From: Hannah Riddle on behalf of Planning.Responses
Sent: 21 June 2022 10:43
To: Planning Scanning
Subject: FW: A/59/22/PL Fargro, The Vinery

I met the applicant on site last Thursday and I can confirm that I have no further objection to the proposed extended hours. However, I recommend that the scheme should be amended accordingly to reflect that the old building to the left upon entrance site will not be affected by the proposed extended hours.

PROPOSED SITE PLAN

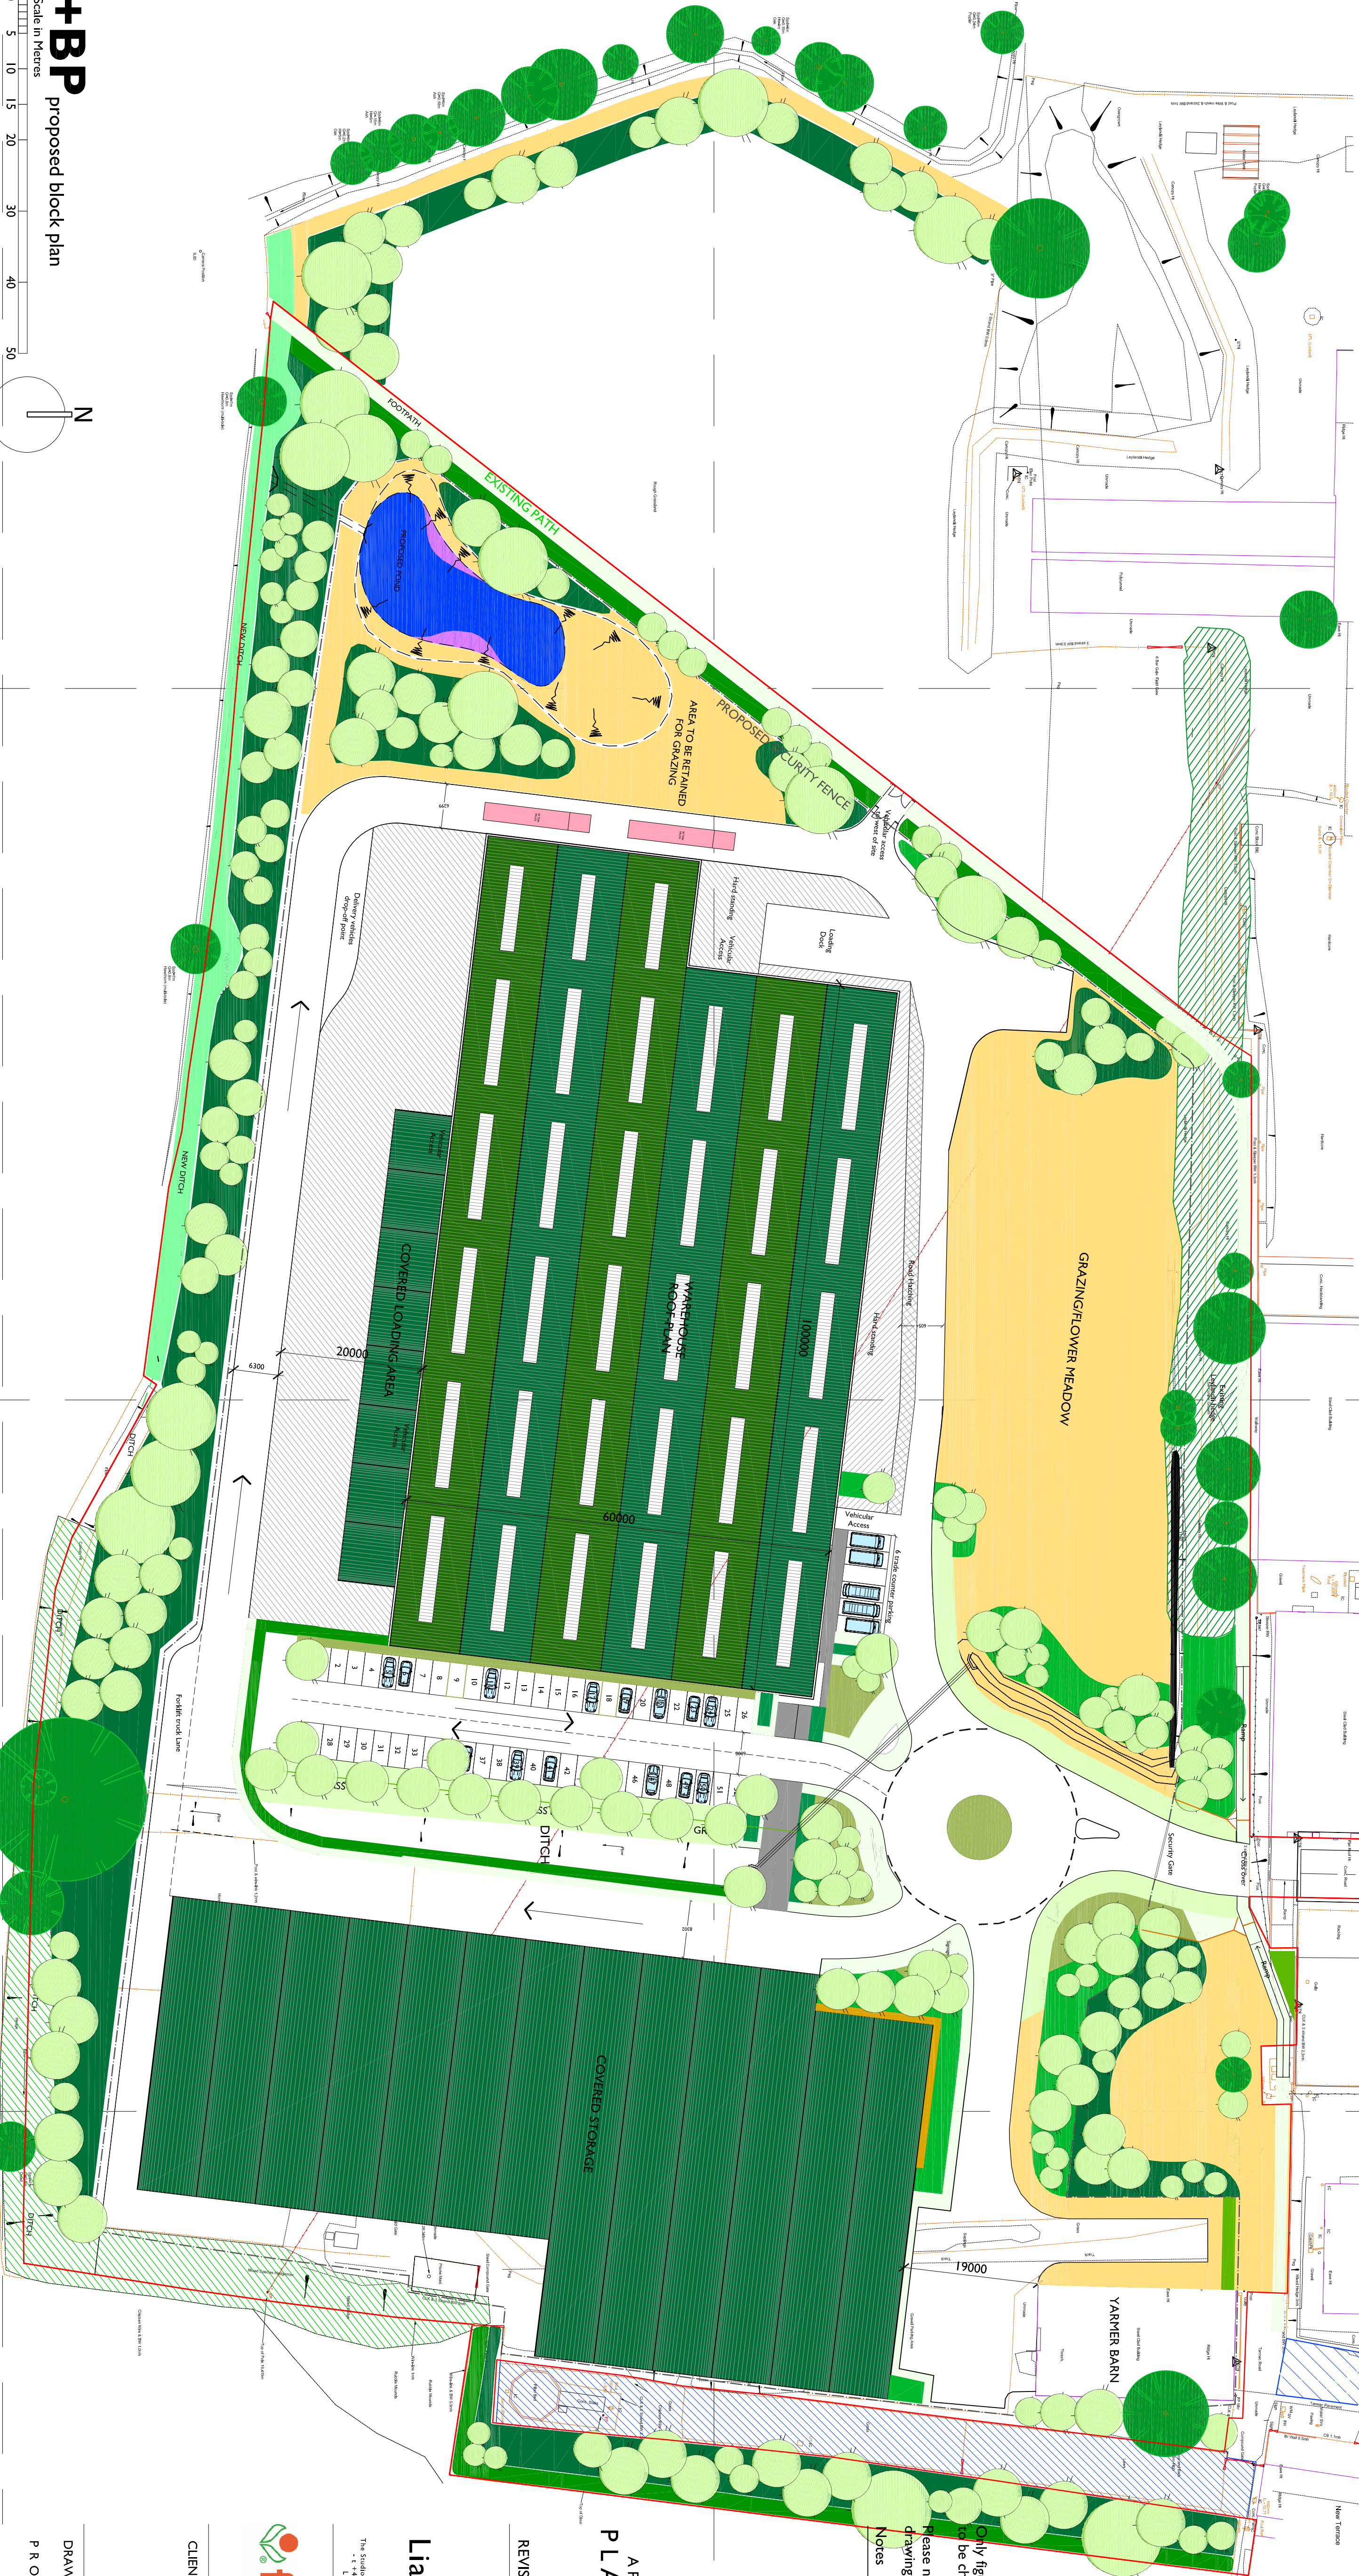
Secondly, we would be prepared to accept a planning condition ensuring that no external operations would occur during the proposed extended hours period in an extended area adjacent to the residential properties. (see attached plan – exclusion area marked in red)
